From: Simon Watts [REDACTED]
Sent: 08 March 2021 15:33
To: Planning
Cc: John Wheatley; Yves Pascal; iqraa.malik@terraquest.co.uk; Finlay Gardner
Subject: Re: AB/19/21/HH - 32 Maltravers Street Arundel - Request for Update on Planning Application

We write with reference to planning application **AB/19/21/HH (32 Maltravers Street, Arundel, BN18 9BU)** that was submitted online on 19 February 2021 on our behalf by our agent John Wheatley of John Wheatley Architecture.

The current drawings and their revisions are:

project: 32 Maltravers Street - Arundel - BN18 9BU			
drawing title: Existing & Proposed Ground Floor Plans			
drawing status: Planning Application Proposals			
date: 01 - 03 - 2021	scale at A3 original size 1:100	no: JW2012ARU - PL04	rev: E

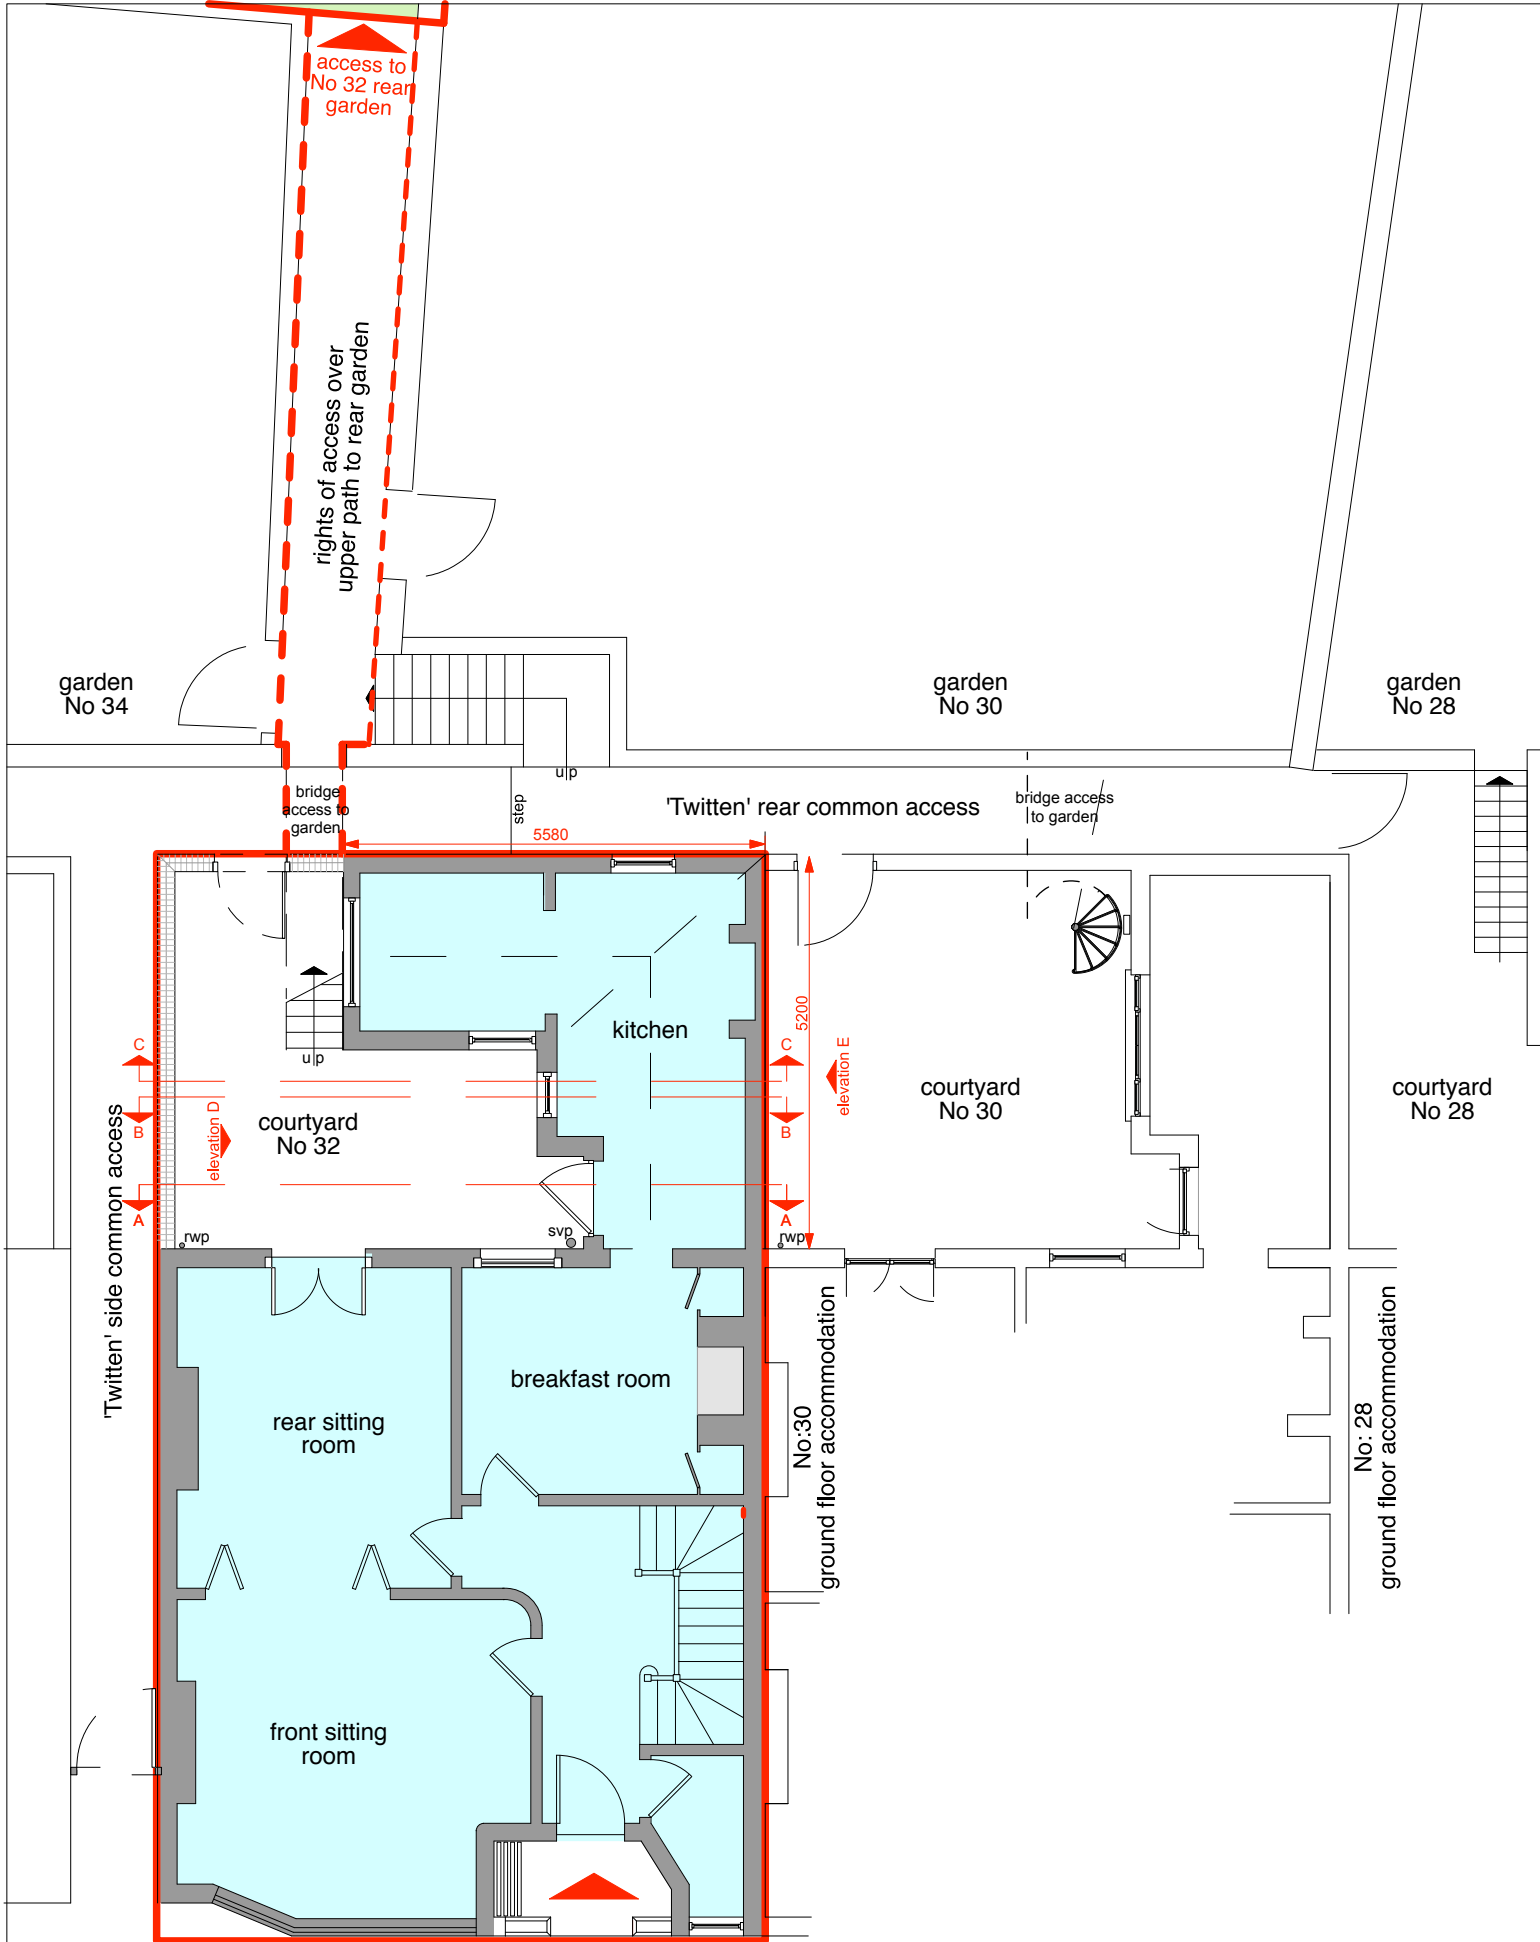
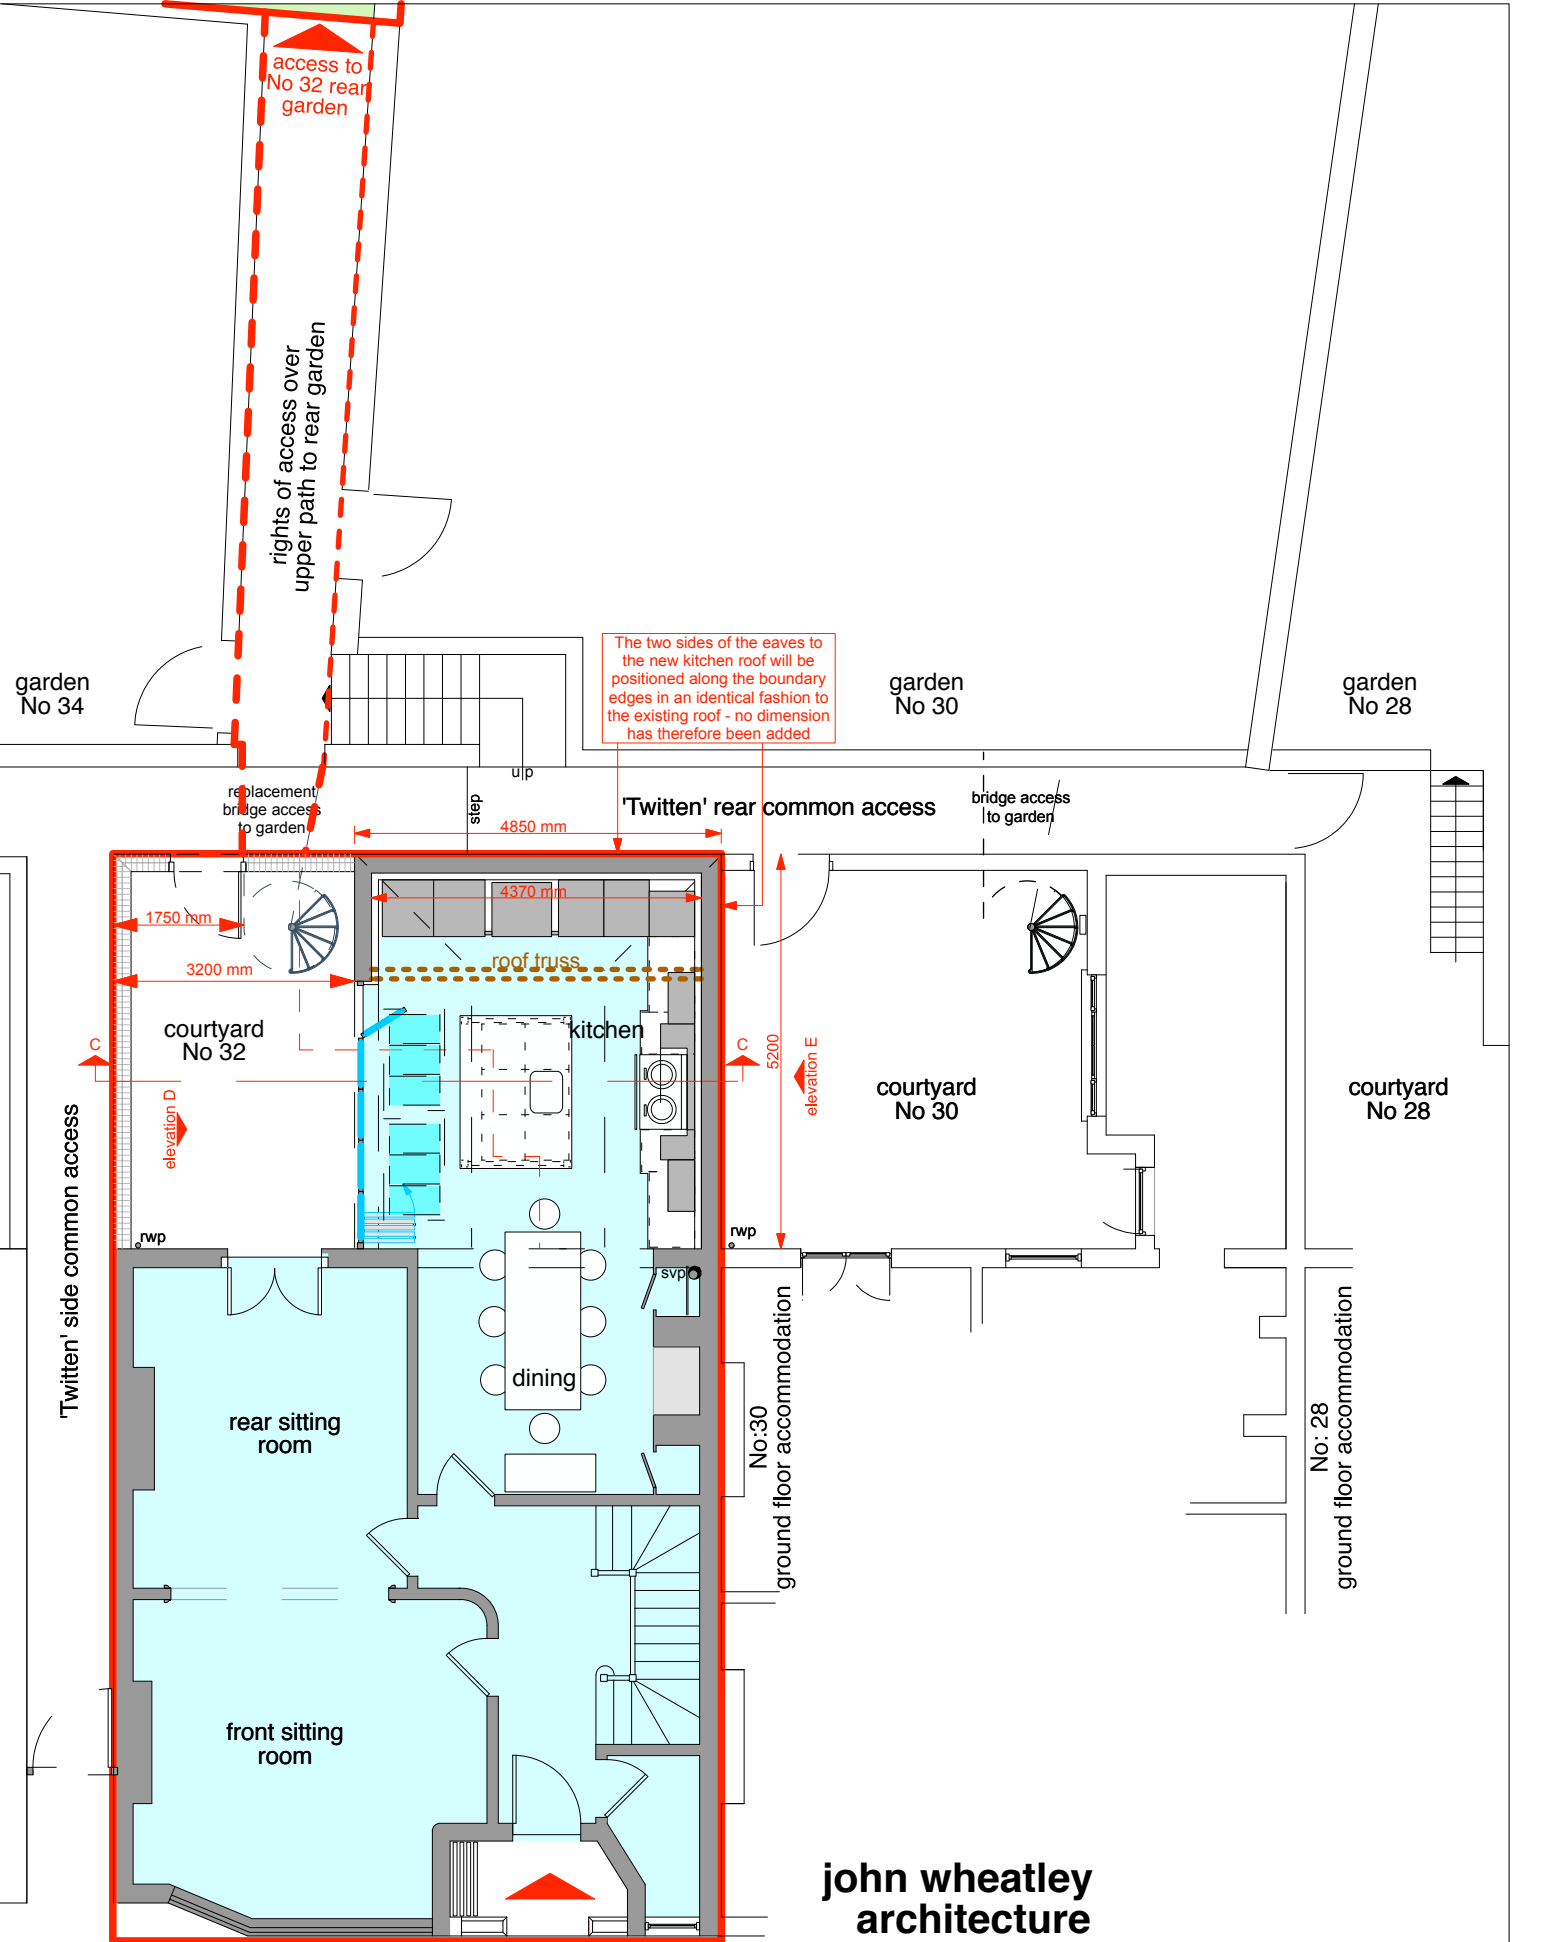
- Dimensions: You are required to include dimensions from the proposed extensions to all site boundaries. Apologies for this omission - I have now added dimensions to the courtyard on the Proposed Ground Floor Plan on a now later revision of PL04.

PL04 Rev E - Existing and Proposed Ground Floor Plans 100 - (this also includes the dimensions requested although not essential to the application)
